From: Alison Meeus [REDACTED]
Sent: 22 August 2017 09:51
To: Anita Gardner
Subject: More information

I have heard back from the engineers and they have the following questions/comments to make:-

DITCH CULVERTING WORKS Scale 1:25

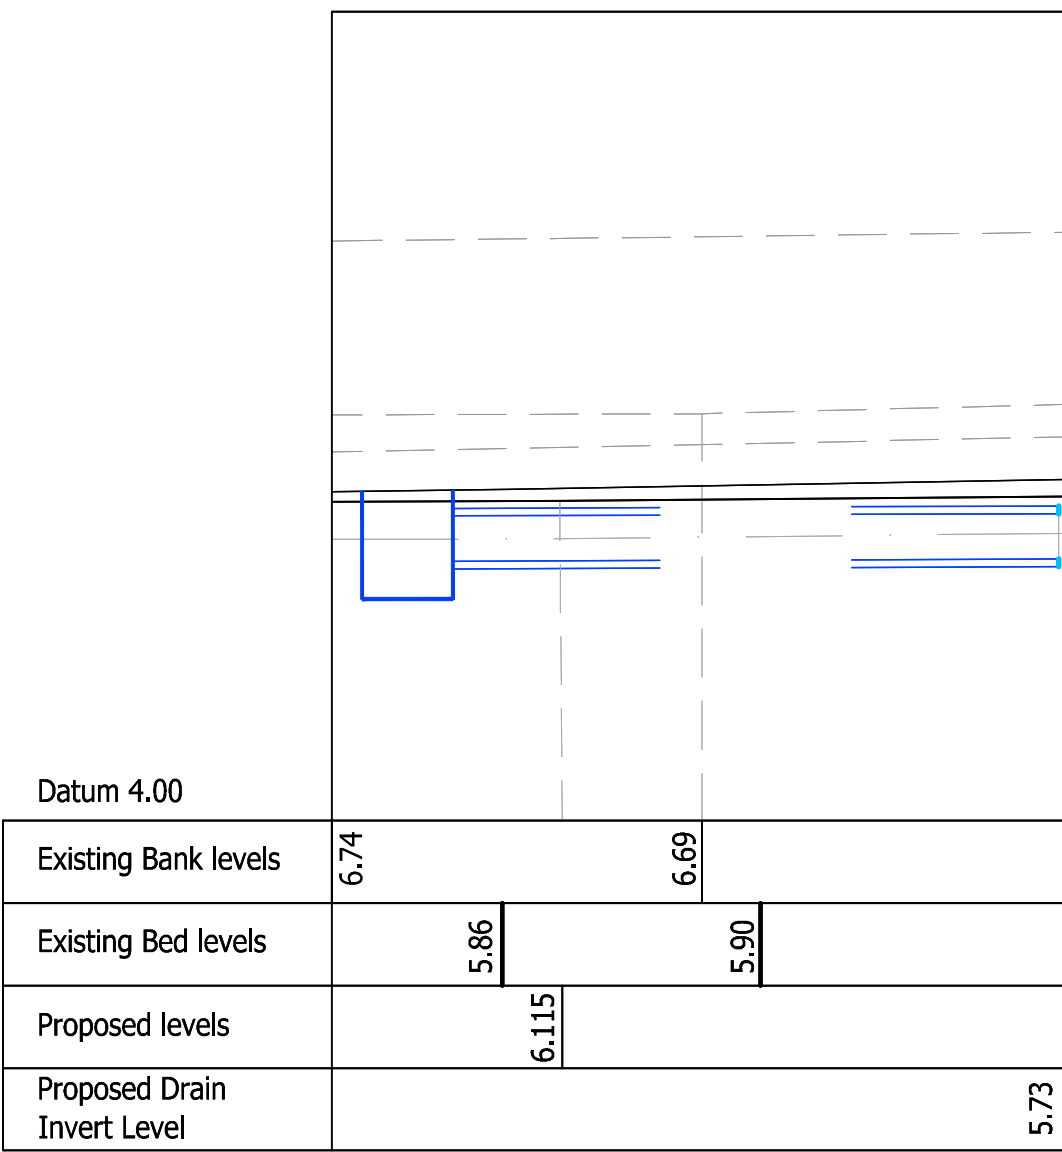
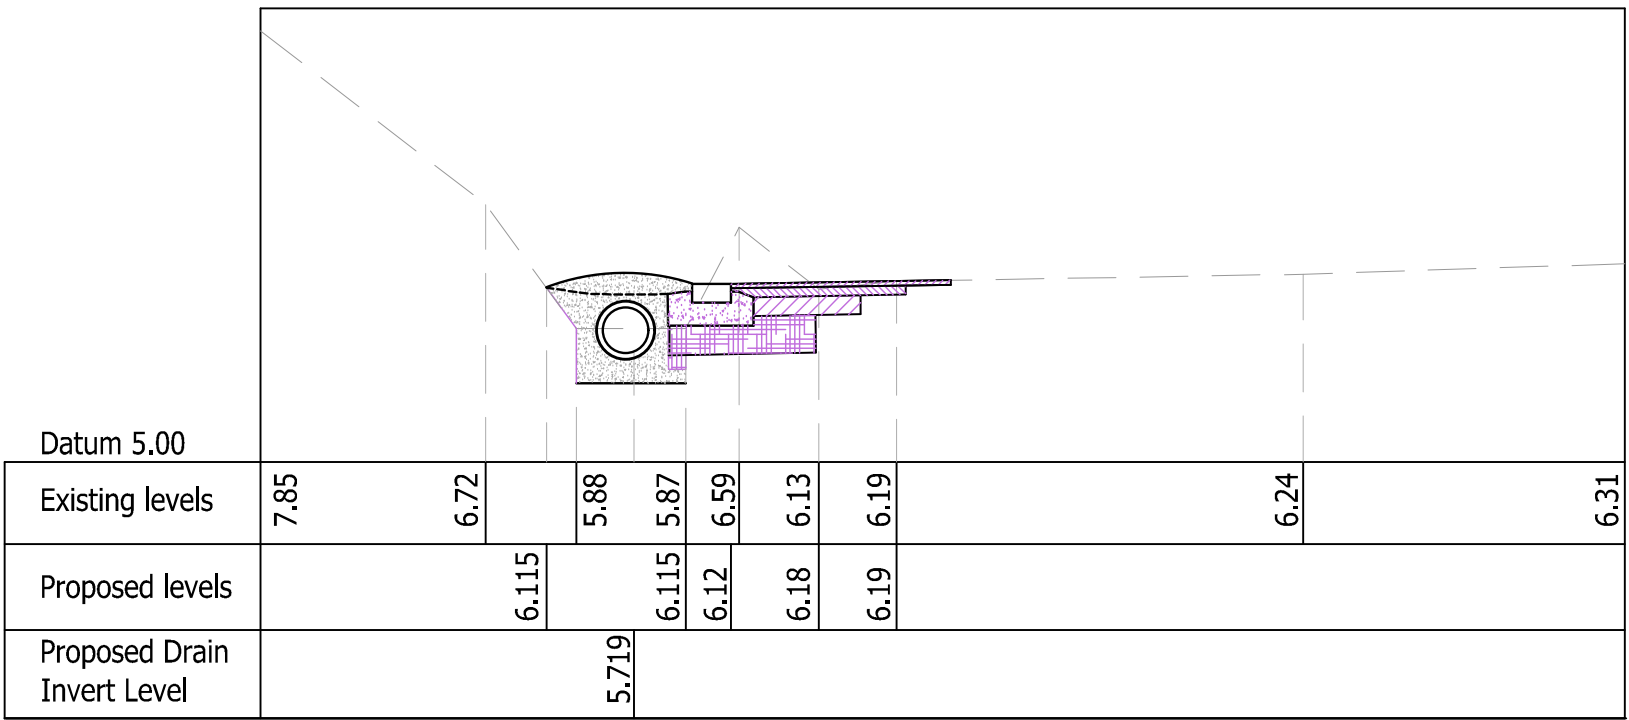
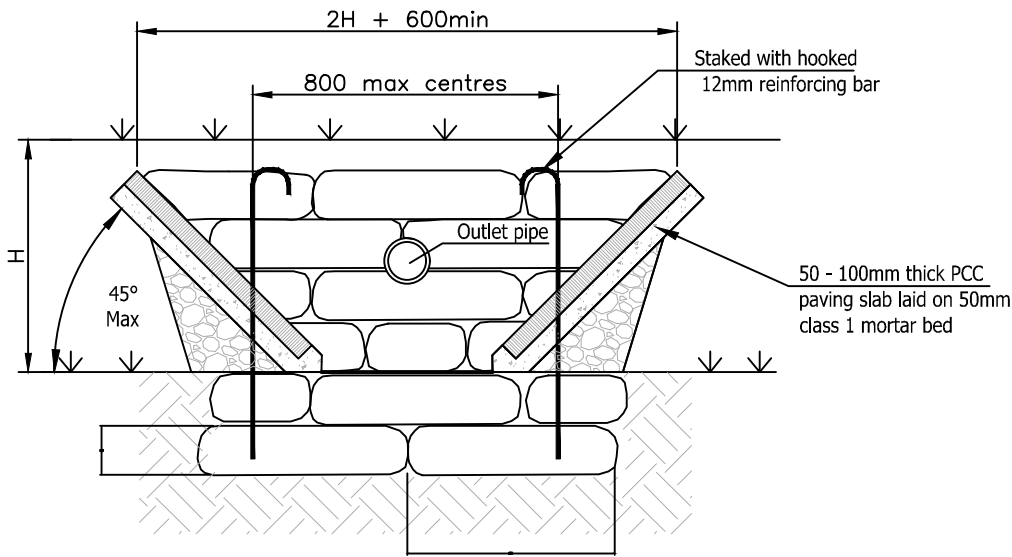
2) Any works to the ditch or use of the airspace above the ditch would need landowner consent.

3) The piping of the ditch will still require consent from the district council.
